## Application for a Non-Material Amendment Following a Grant of Planning Permission

Erection of agricultural building

PF/23/0210

Slight increase in length due to construction details

A 28-06-23 Length changed from 24.4m to 18m, width changed from 12.2m to 10m, roller door and personnel door added to other end, rooflights added.  
 B 13-02-24 Slight increase in length due to construction details.

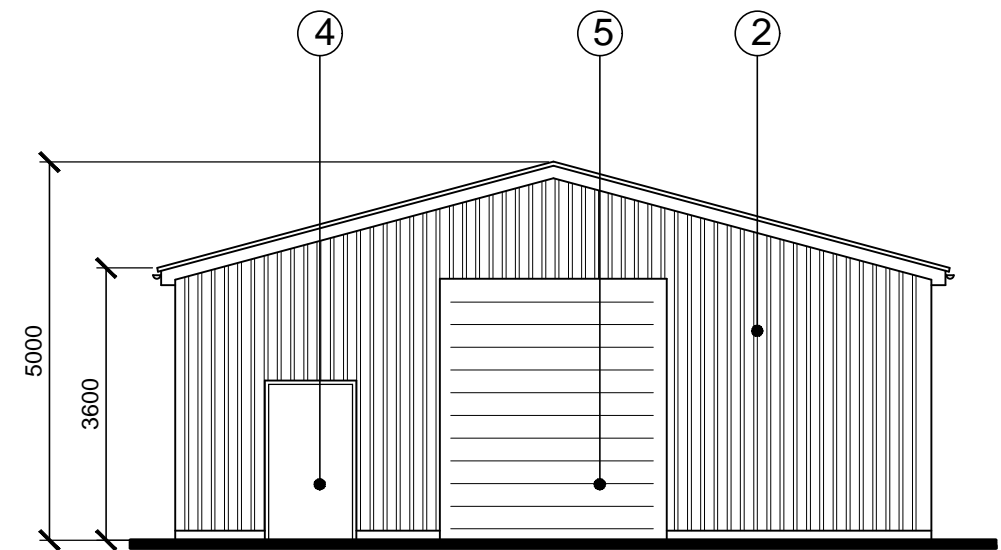
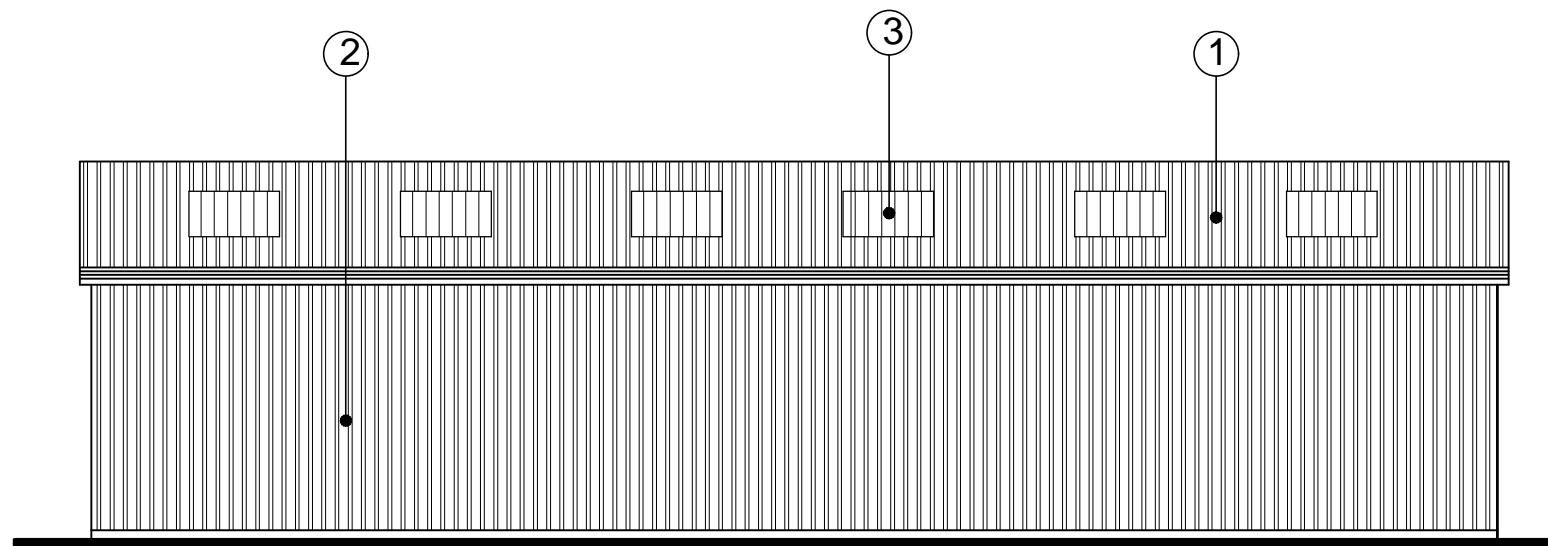
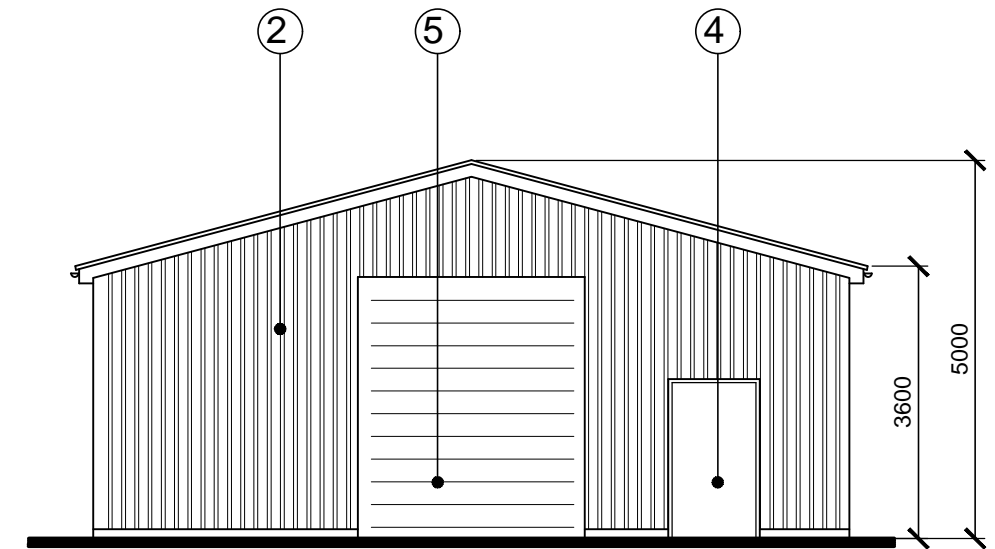
SW/23/02/L24b, SW/23/02/L25b
